DRB Application No.: **04DRB-00719 (FP)**

Project Name: **Santa Fe @ The Trails**

**CITY OF ALBUQUERQUE
PLANNING DEPARTMENT**

RE: Santa ^{Fe}@ The Trails/final plat

Drawn By:	RJA	Date:	05-10-04
Checked By:	TA	Drawing Name:	04017PL1.DWG
Job No.:	04-017	Sheet:	2 of 3

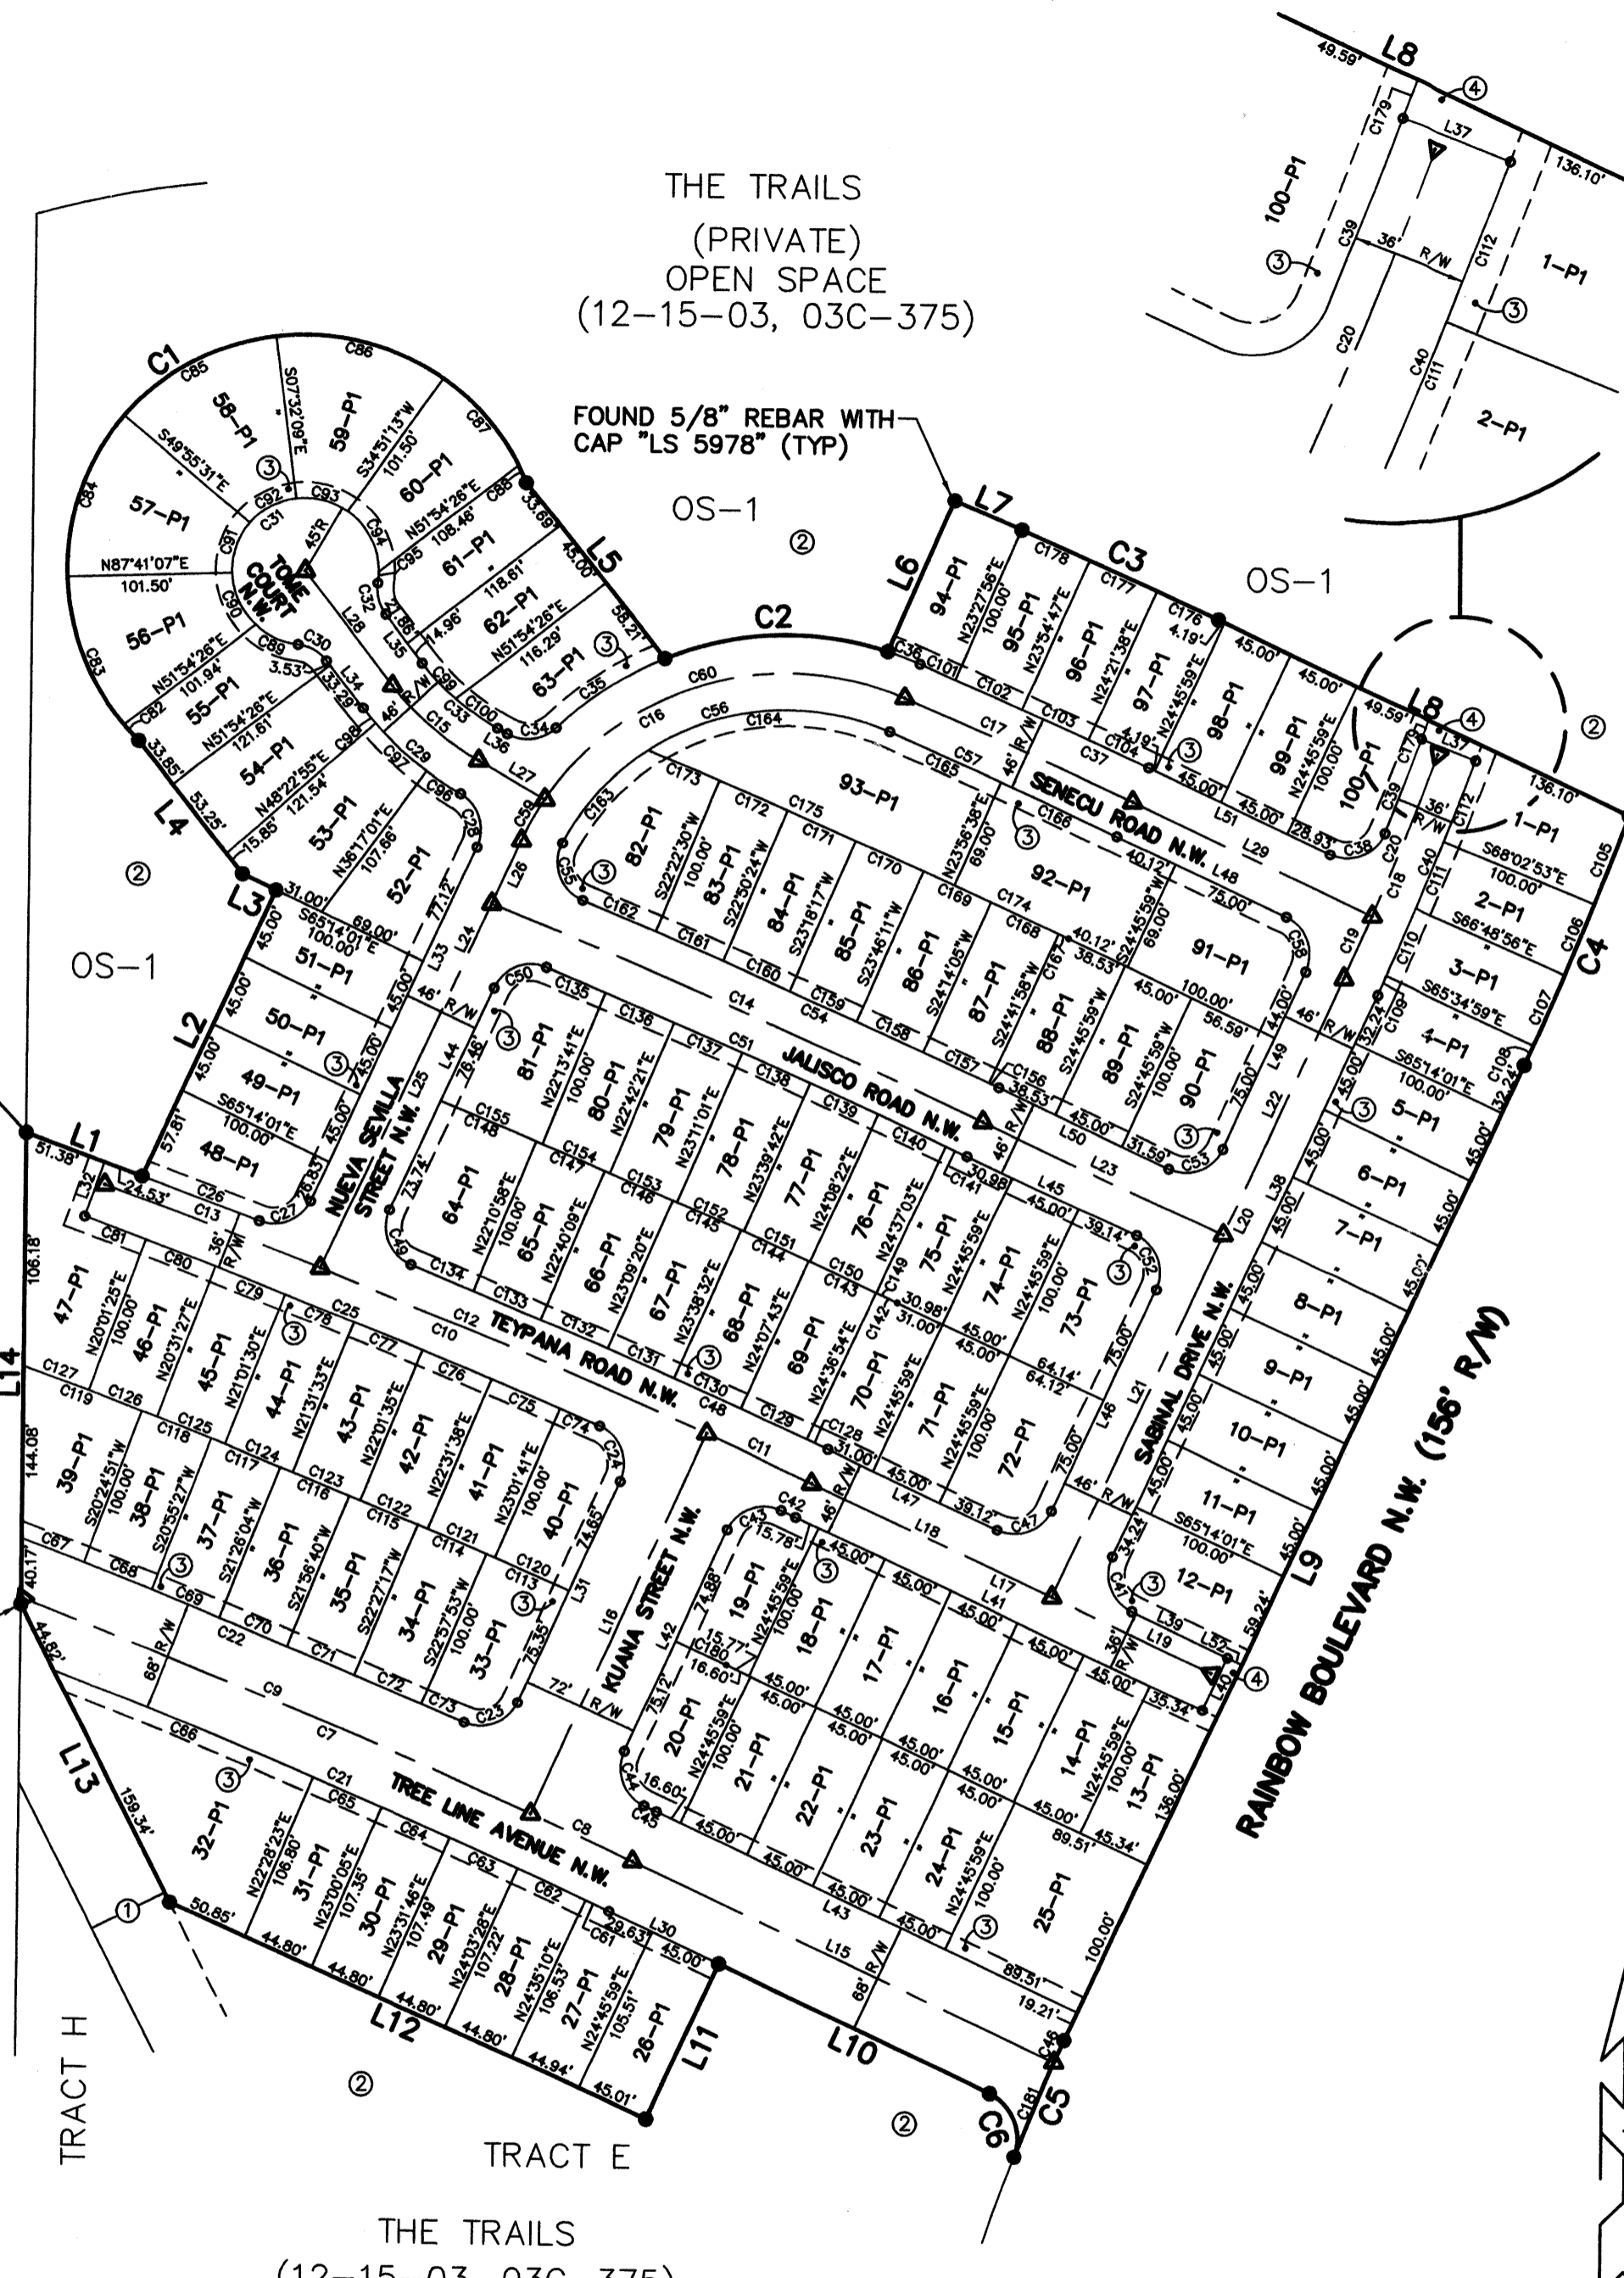
The plat needs this language above the owner's signature: "Said owner warrants that he holds complete and indefeasible title in fee simple to the land subdivided".

Were there any changes from the approved final plat?

Is the zoning listed on the plat?
